Consultation Response KC Landscape			
Planning Number:	2025/93449		
Proposal:	Discharge of details reserved by conditions 27 (crime prevention), 29 (boundary treatments), 30 (external lighting), 31 (landscaping) on previous permission 2024/90991 for variation of conditions 2 (plans), 28 (materials) on previous permission 2020/93358 for erection of 52 dwellings – revisions to layout, house types, unit size mix and external materials		
Location:	Land east of, Abbey Road North, Shepley, Huddersfield, HD8 8FG		
DEVELOPER/APPLICANT/AGENT:	Directions Planning Consultancy Ltd		
Planning Officer:	Victor Grayson		
Date Responded:	12.02.2026	Responding Officer:	Landscape
Site Area (Hectares)		Responding Ref:	PP74
<p>NOTES/COMMENTS: COND 31 – Landscaping</p> <p>Condition 31 Landscaping</p> <p>Prior to the commencement of superstructure works the condition requires that details of all hard and soft landscaping are submitted for approval. These shall include:</p> <ul style="list-style-type: none"> • Details of existing and proposed levels, and regrading of areas of public open space; Provided in External works plans 1 & 2 <p>An indication of all existing trees and hedgerows on and adjoining the

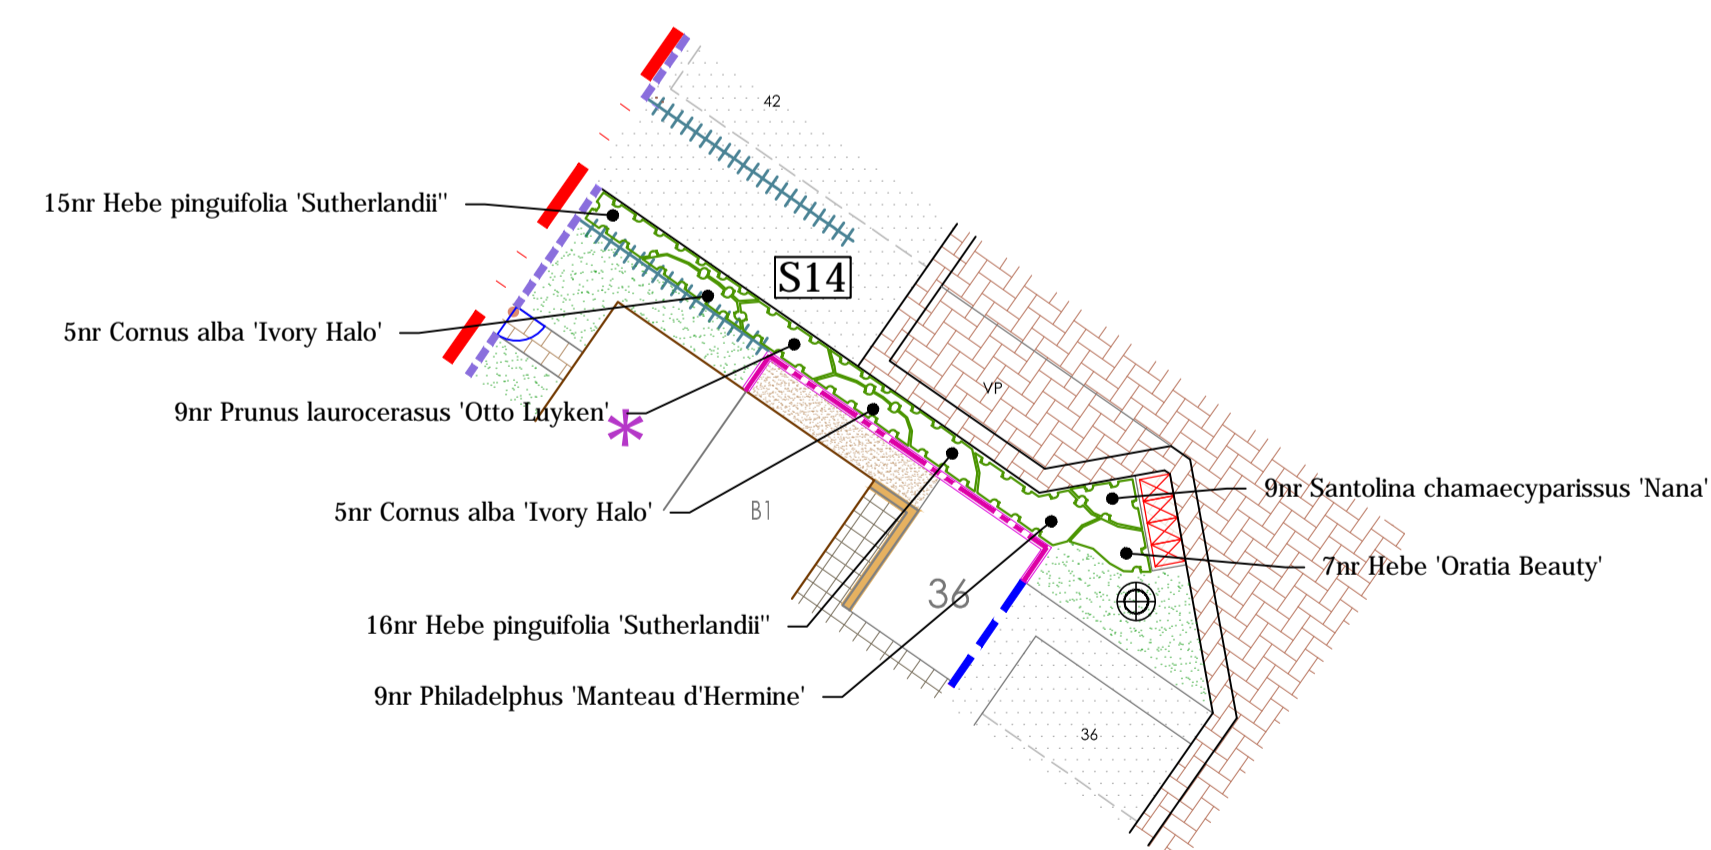
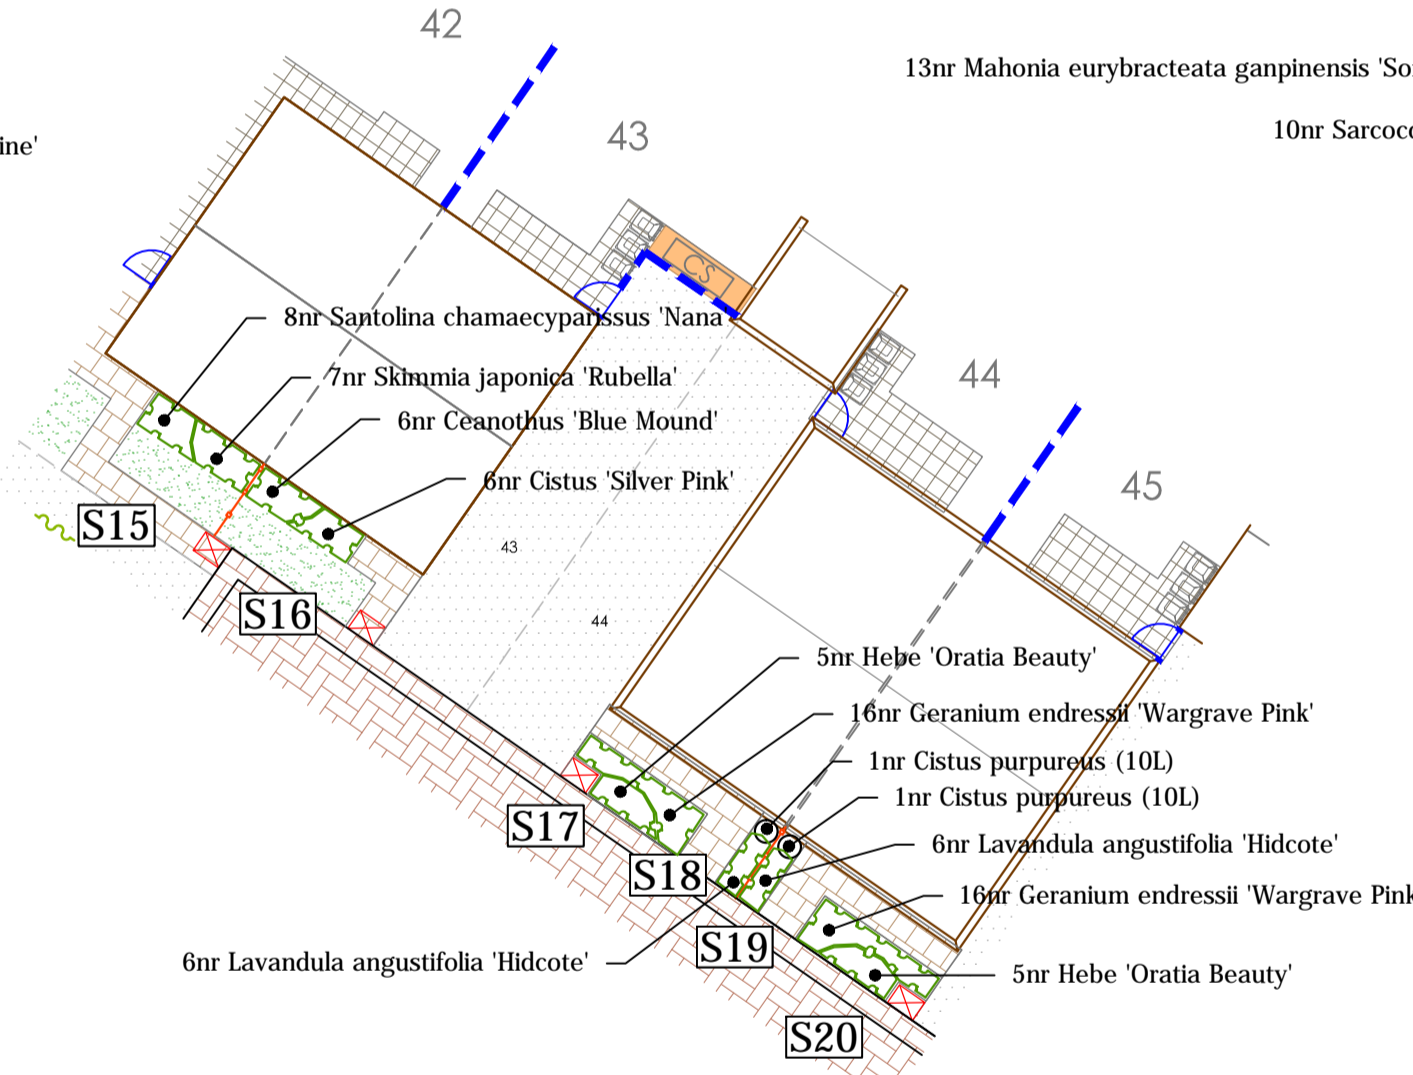
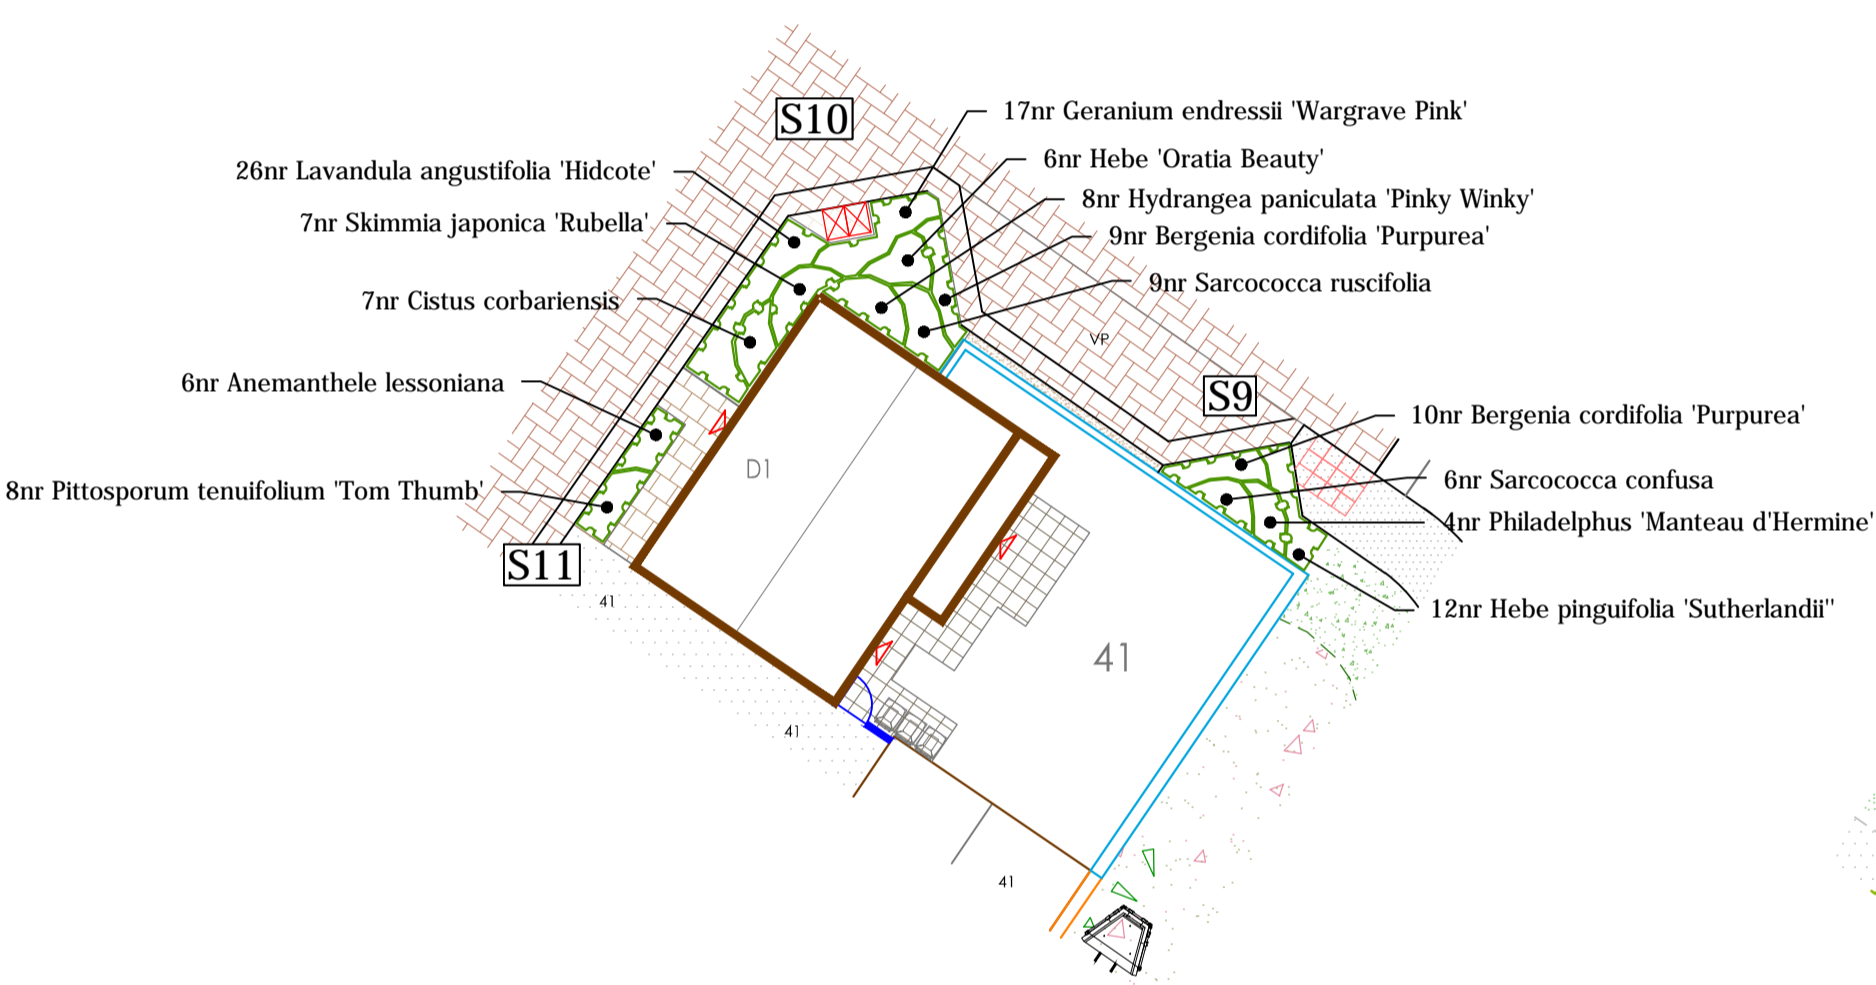
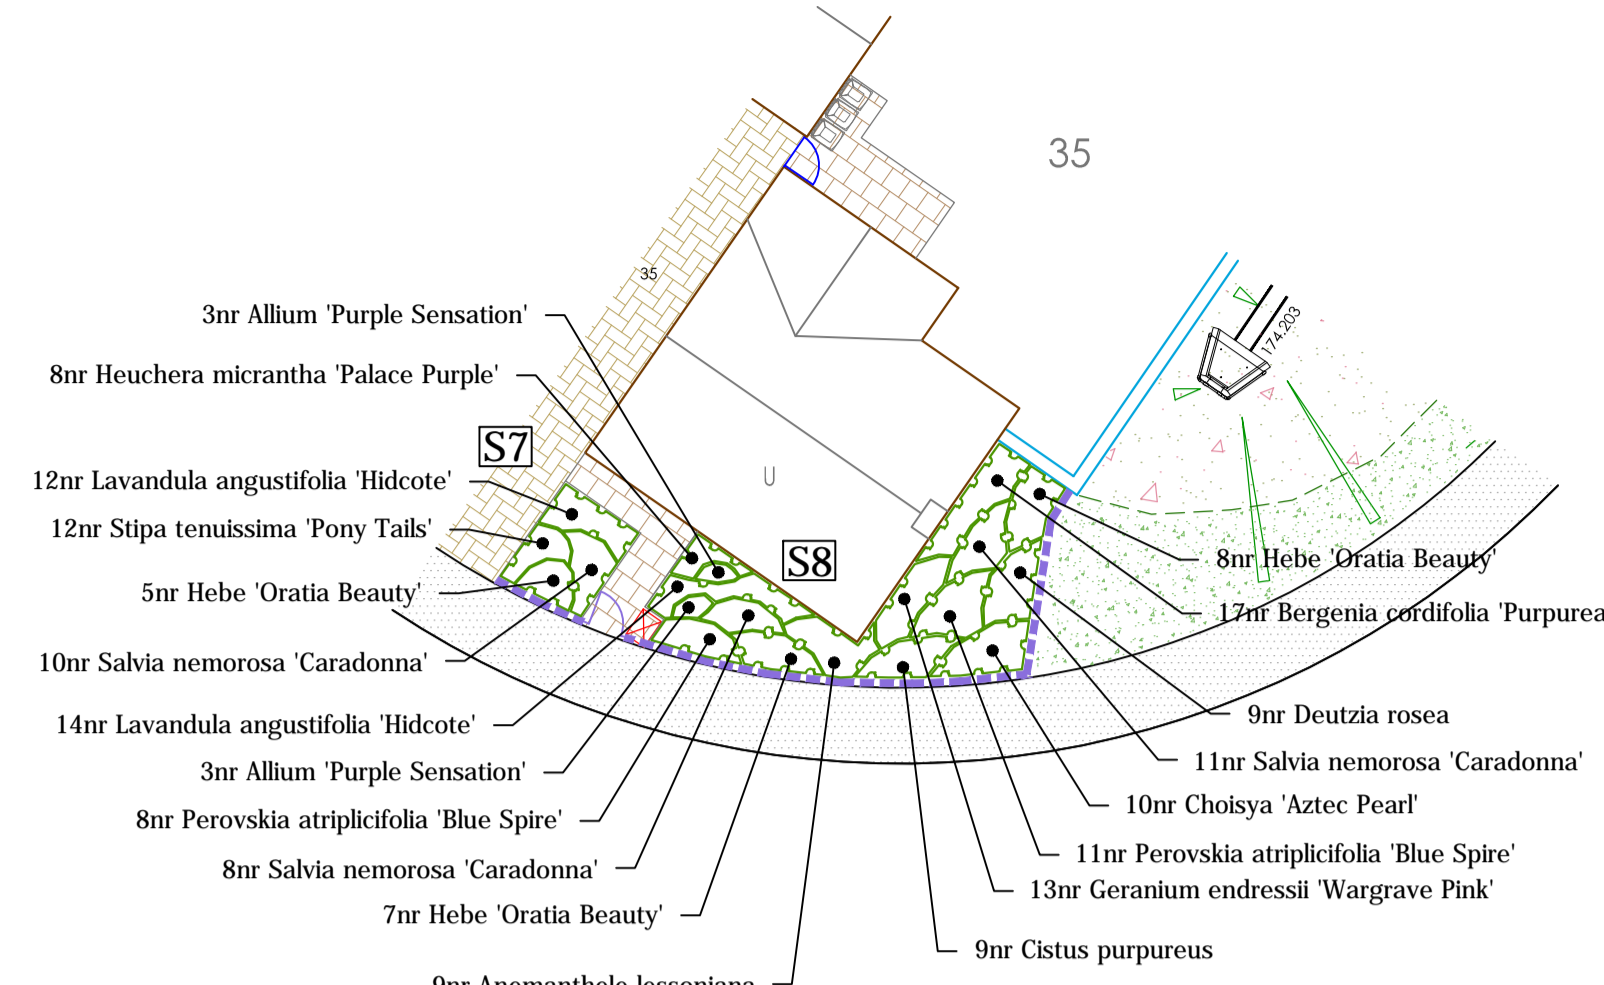
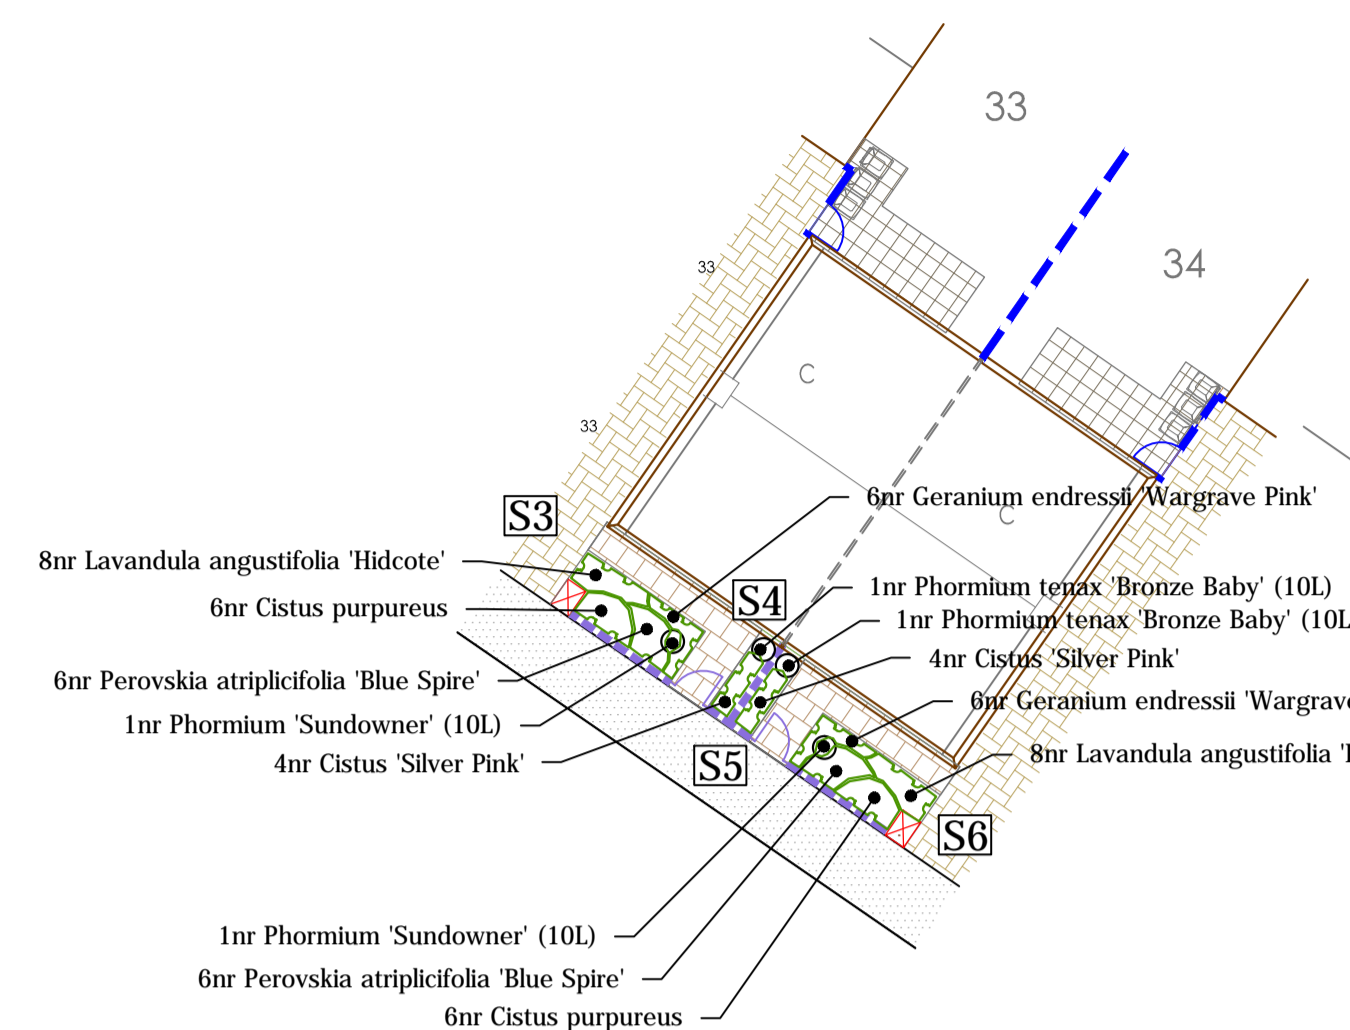
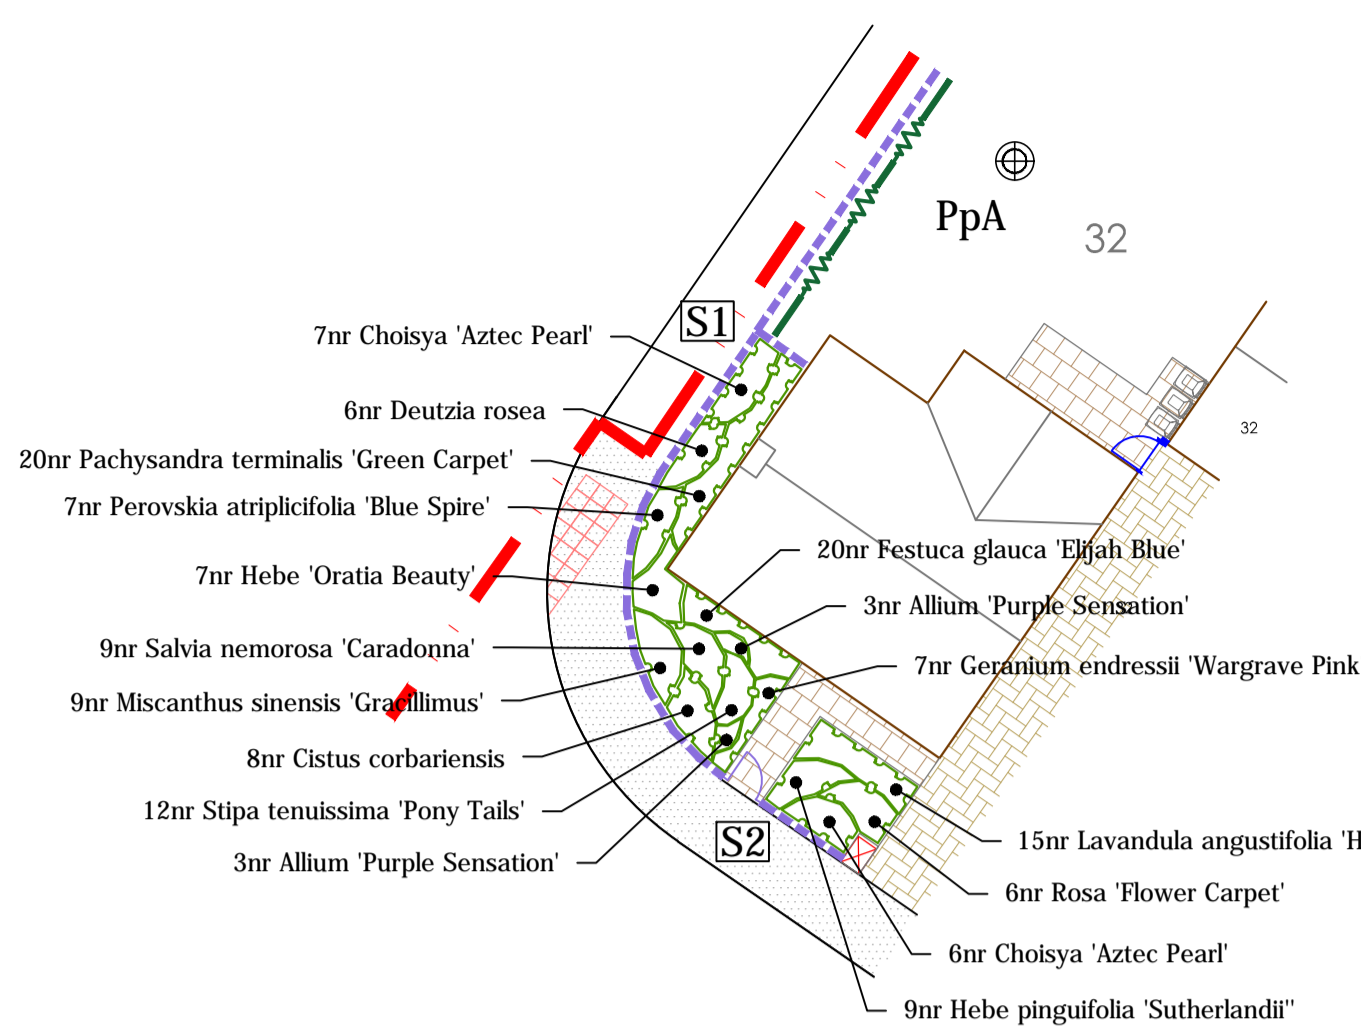
Most of the landscape information has been provided in the Landscaping Masterplan (R-2446-4L) and planting plans R-2446-6, R-2446-7, and R-2446-8. However several aspects as listed in the condition 31 are not submitted with the DoC and I have been unable to locate them.

We cannot recommend the discharge of this condition until further information is submitted to meet each item listed in the condition therefore Condition 31 must remain.
